Sizewell C (SZC)

Planning Inspectorate Reference: *EN010012*

East Suffolk Council comments on Deadline 8 submissions from the Applicant

9.13 Sizewell C Coastal Defences Design Report [[REP8-096](#)]

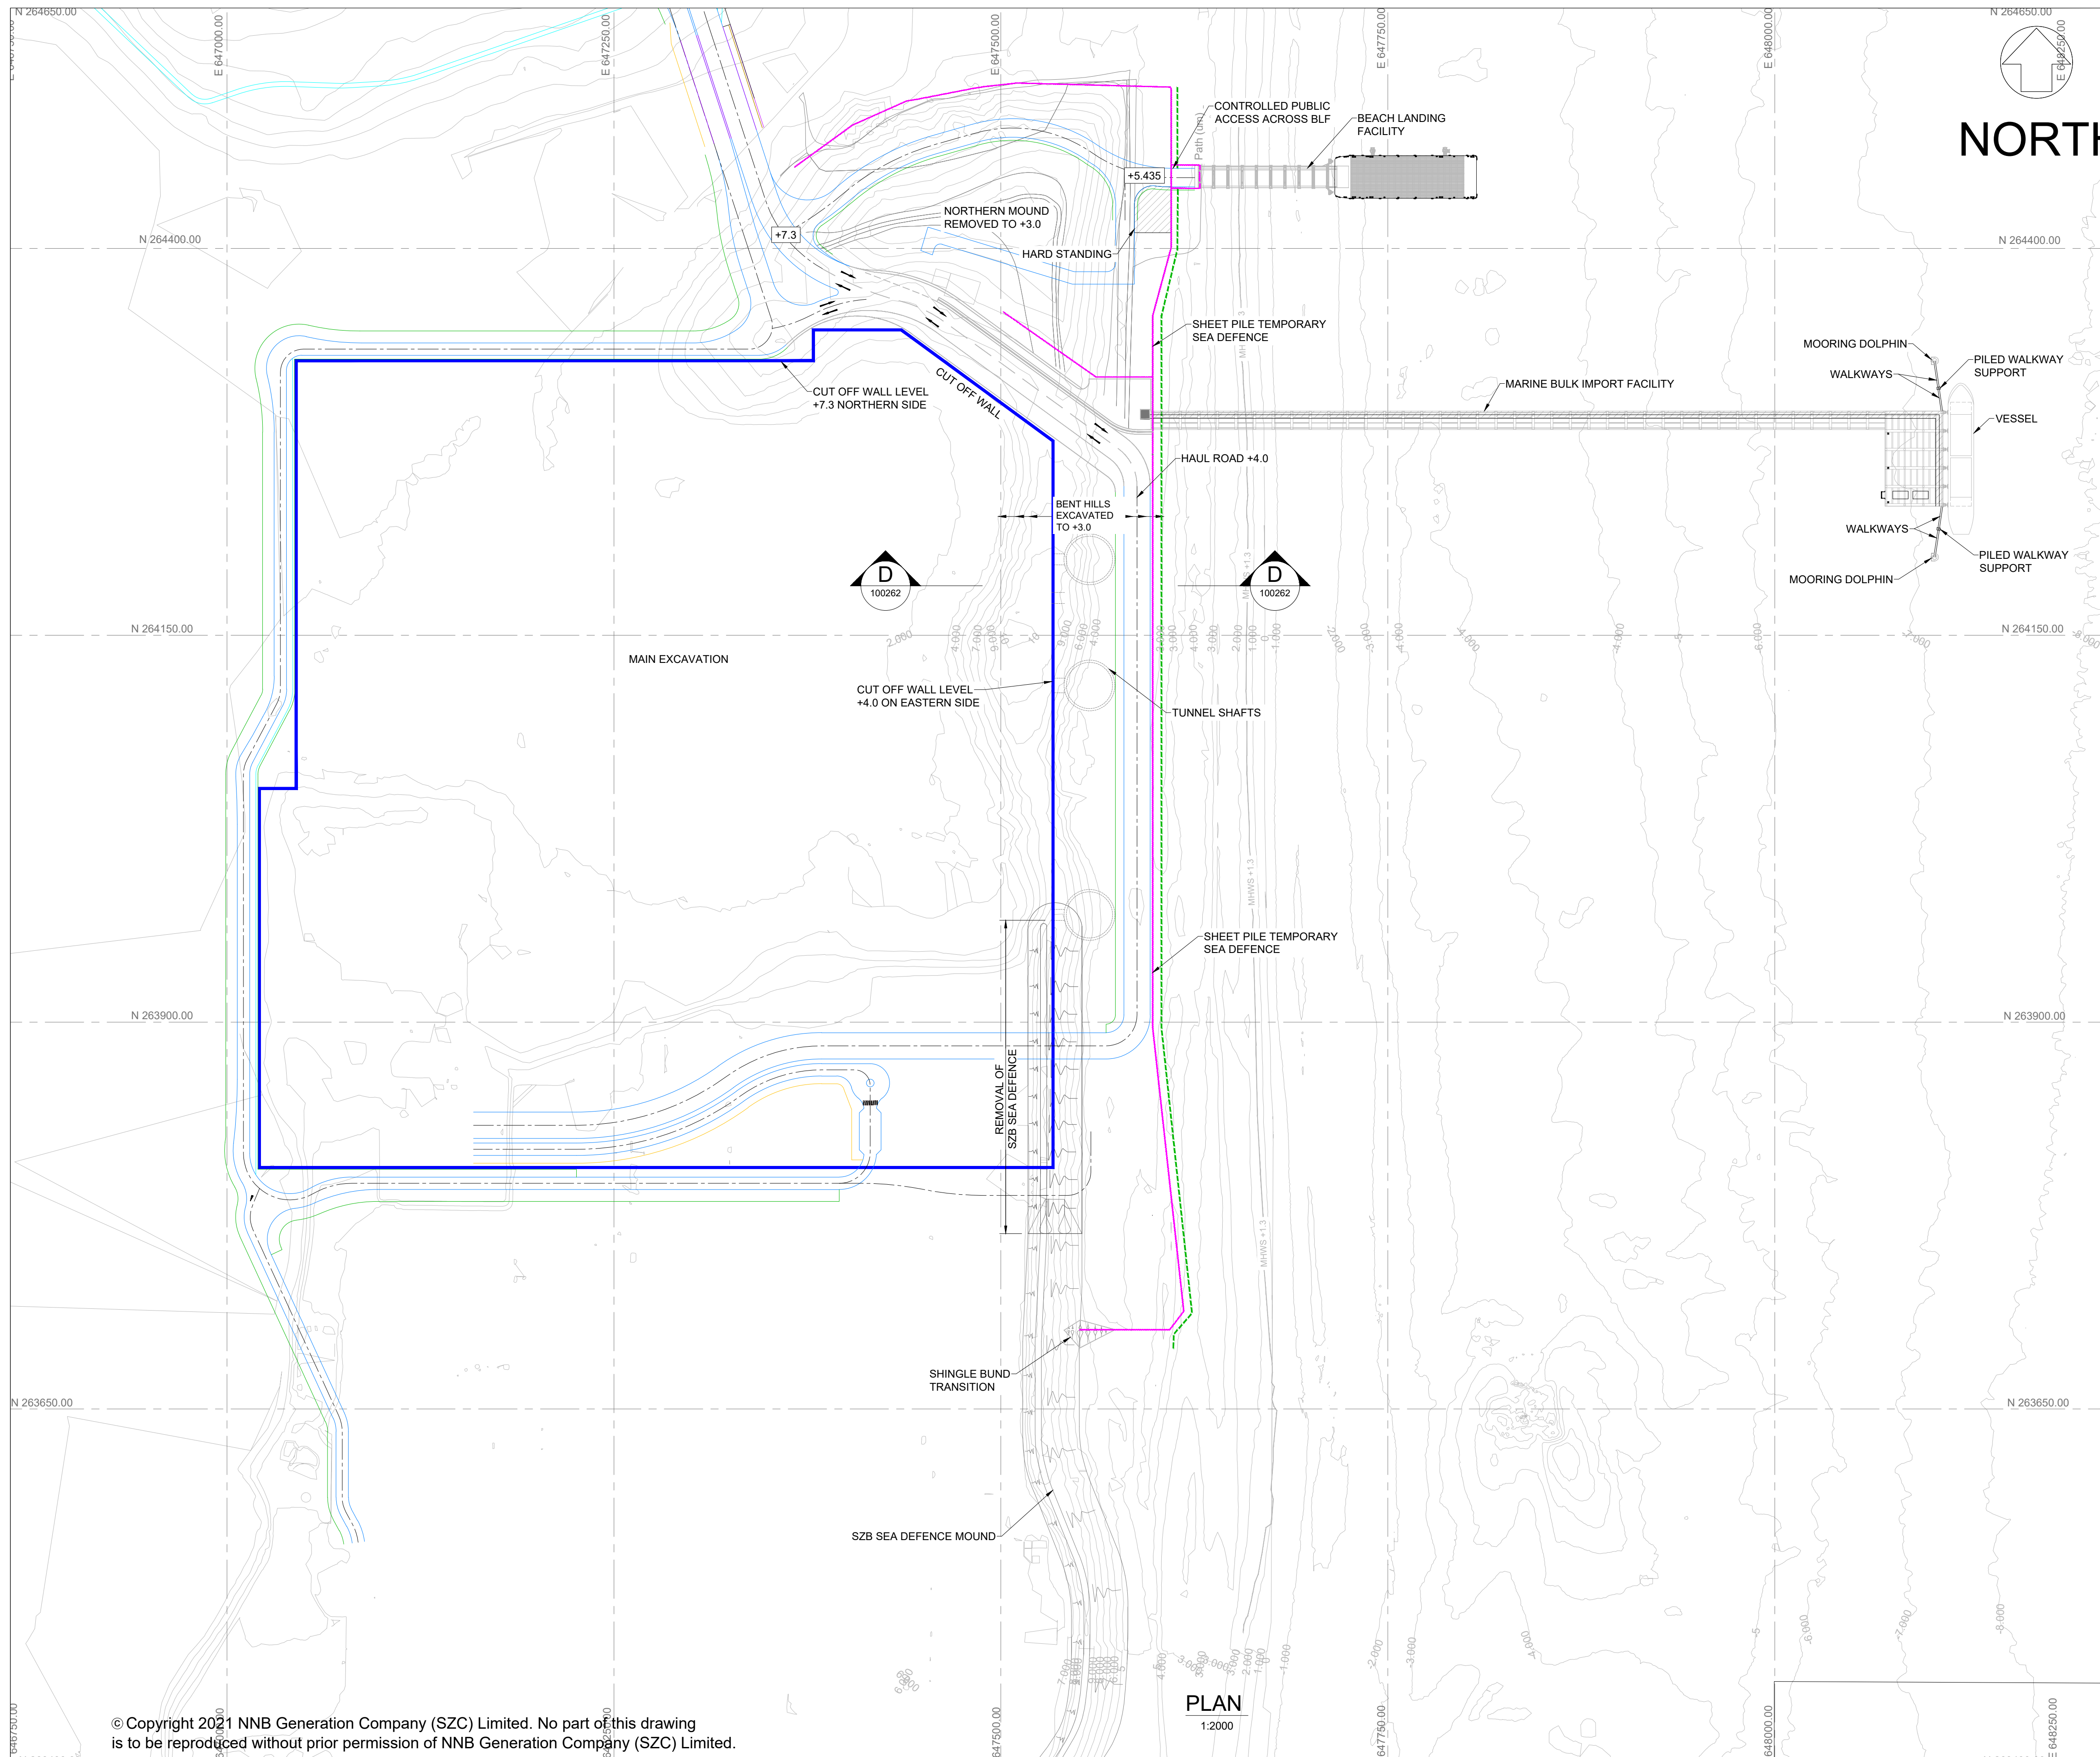
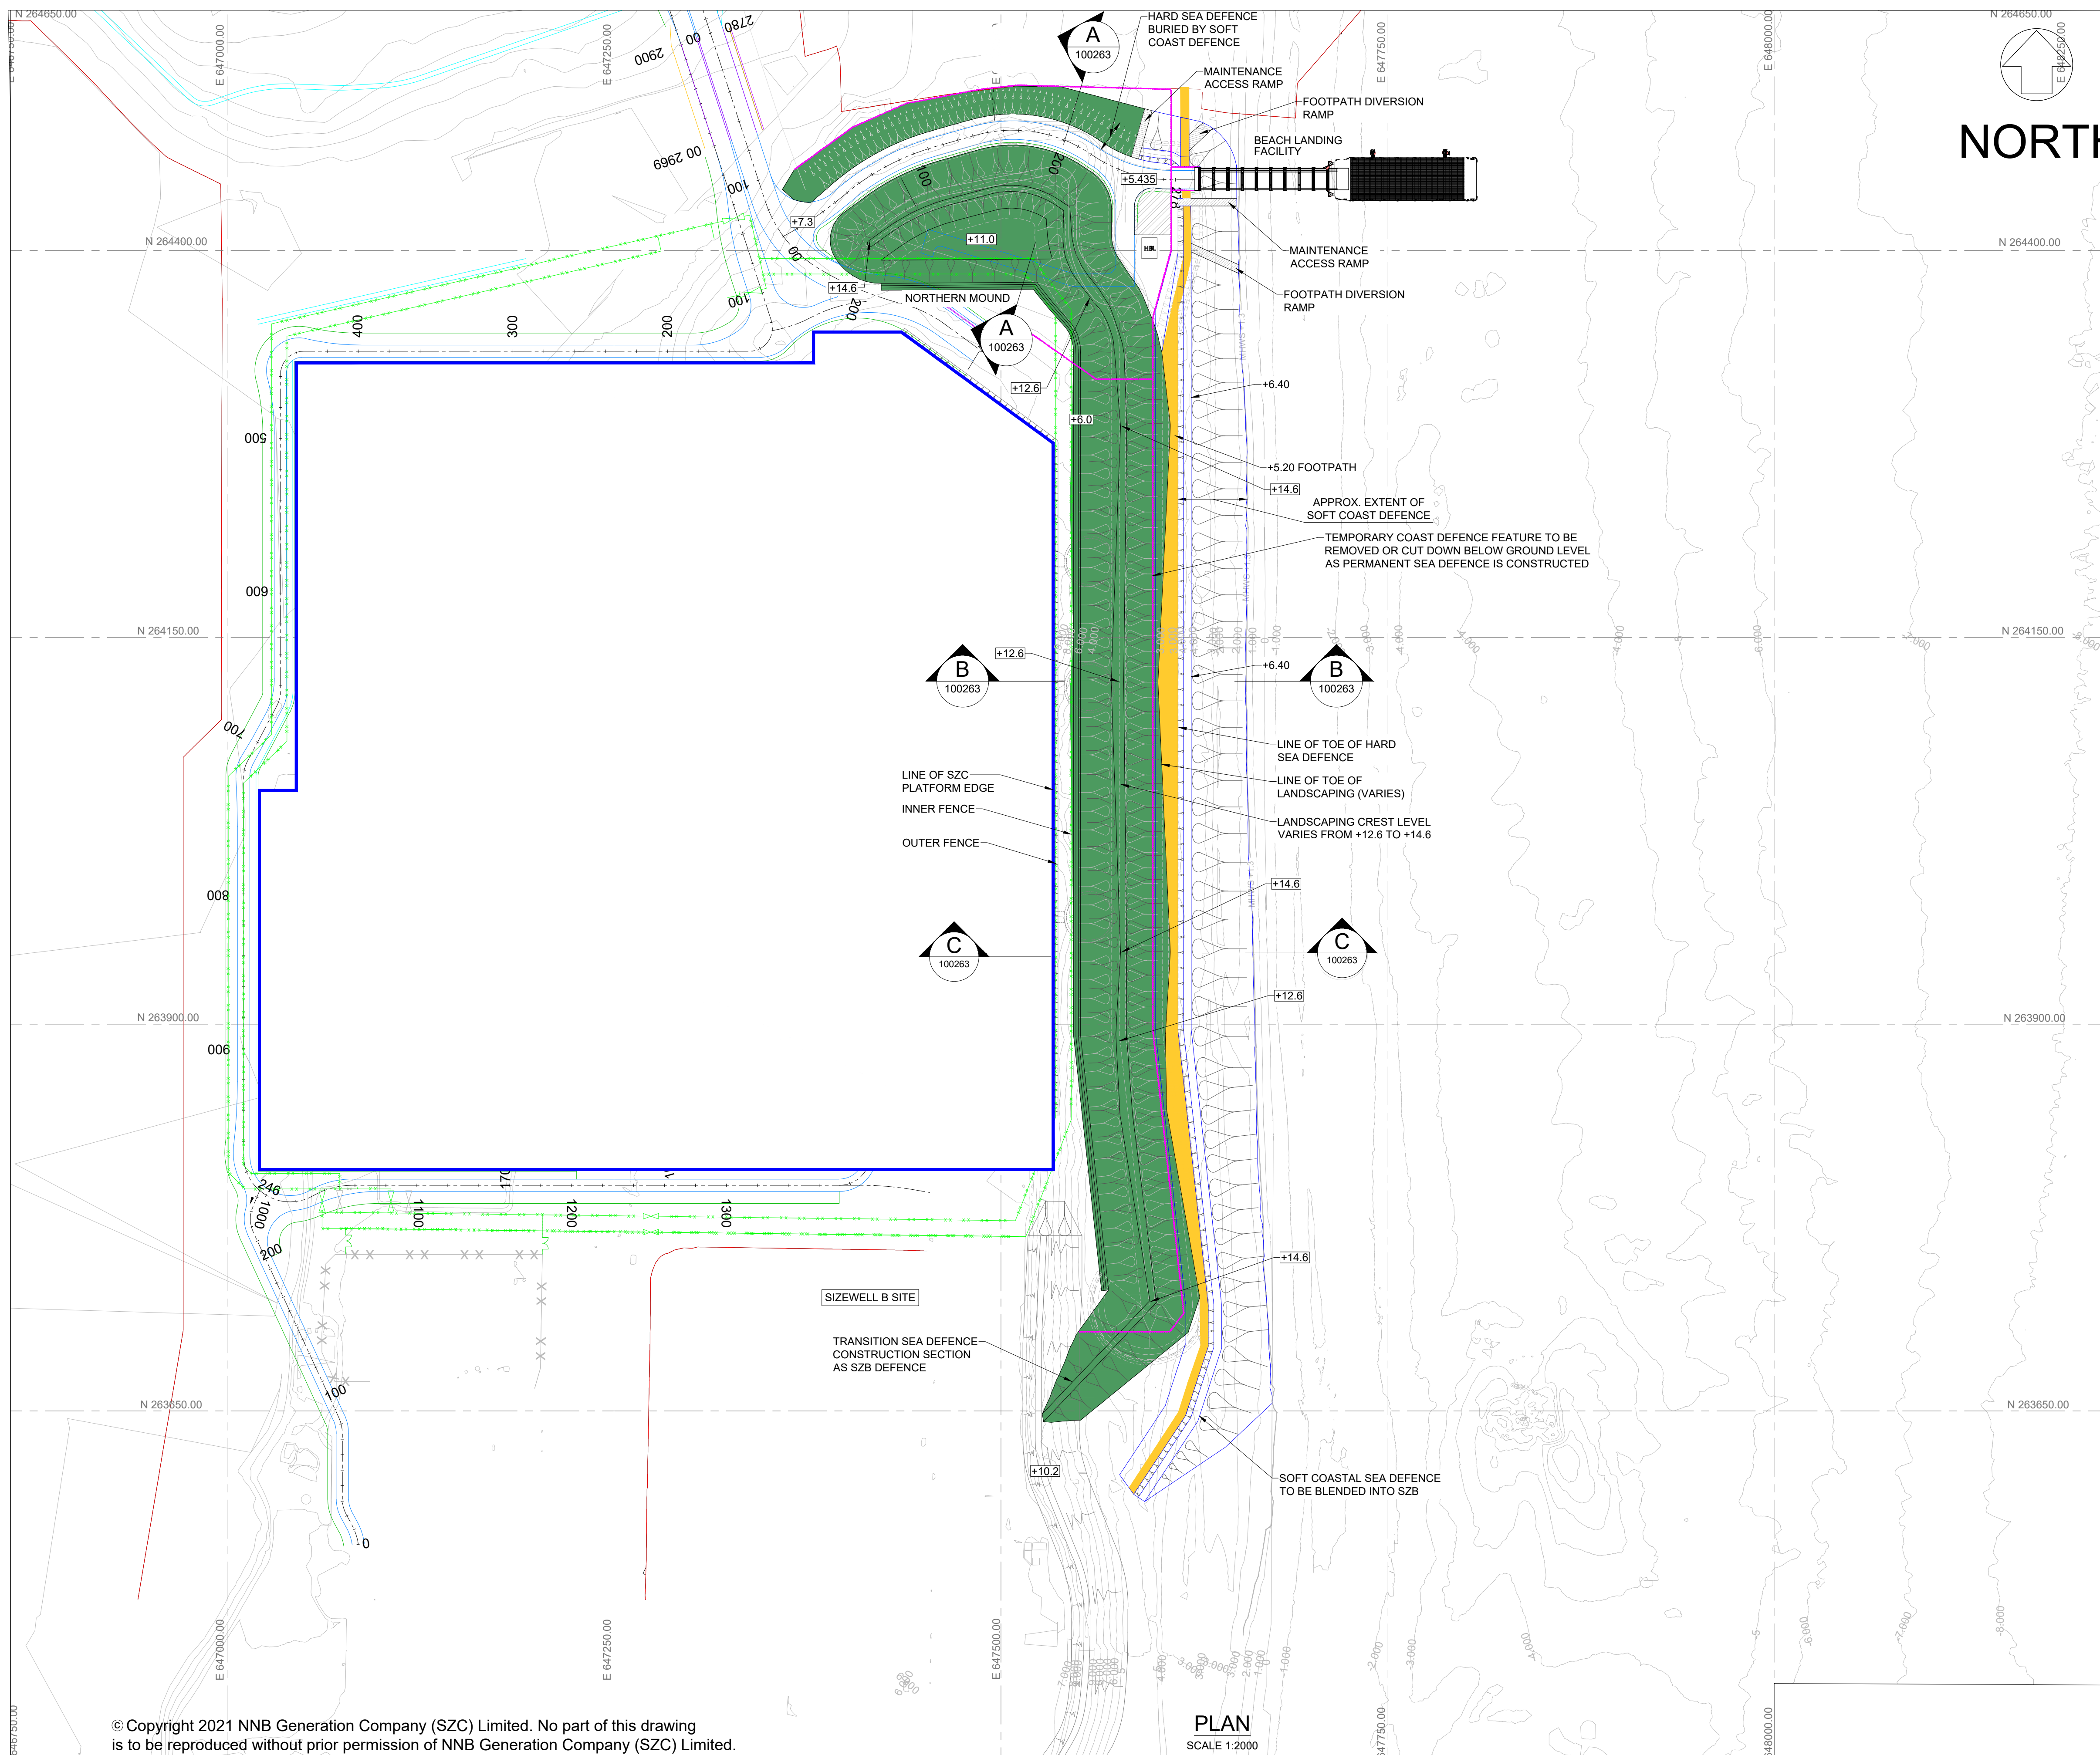
<i>maximum height of +18.0m OD including landscaping</i>		
	<i>Fig 3.1</i>	<p>Figure 3-1 - Sea Defence Layout</p> 	<p>The north end of the HCDF now shows the realigned and more retreated position of the HCDF.</p> <p>The south end overlap with Sizewell B has moved seaward possibly beyond the easting of the BLF promontory.</p> <p>The 'typical' section location is not at the most critical point that would be either the BLF or the Southern kick-out.</p> <p>The SCDF width varies and the seaward line is not straight / even. Is it defined by the MHWS countour?</p>	<p>Further information and clarifications sought:</p> <p>Provide additional sections at BLF and Southern extent showing Temp HCDF, HCDF and SCDFs plus unconstrained shoreline profiles at 2020, 2050, 2080, 2110 and 2140. This has not been provided.</p> <p>Typical XS is at 264015mN. In figure 3.5 a 2014 beach profile is used.</p> <p>Provide legible underlying bed contours across the whole frontage, not just confined to the north end. Extend to show a portion of Minsmere. This has not been provided.</p>

<p>Provide a legible scale and identify the easting/northing lines. This has not been provided.</p> <p>Why do the south ends of the HCDF and SCDF not coalesce with the structure and alignment of the Sizewell B bund? How has the SCDF width and seaward extent been determined? Explanation has now been provided.</p> <p>Is the HCDF toe detail at the BLF at the Adapted profile level (-1.5m ODN)?</p> <p>Explain why the temp piled defence moves outside the perm defence footprint at the Northern end. Temp HCDF removed at northern end.</p>
--	--	--	--	---

<p>Light temp piling to protect SSSI from contamination during works.</p> <p>Will the temporary piled defence outside the footprint be fully removed when decommissioned? Light piling - yes.</p> <p>We understand that the Sizewell C coastal defence feature is not allowed to make contact with the Sizewell B coastal defence, as the latter is a live operational power station. However, according to the drawing, the two defences <u>are</u> in contact. Please advise / provide the redesign.</p> <p>Further comment is given later in the review.</p>
--	--	--	--	---

Fig 3.1	<i>See also point 3.6.2 'This area of the sea defence is closer to the existing line of MHWS and therefore has a smaller beach volume in front of it than the main run of the sea defence.'</i>	Impact of red line site boundary on works. Appears to constrain the SCDF at southern end splay and works at northern mound. Red line is assumed to be MHWS contour.	Does the site boundary limit the extent of the SCDF and any future adaptive works? This is implied by 3.6.2. If yes, what are implications of those constraints on the Adaptive profile? If NO what is the purpose of the site boundary?
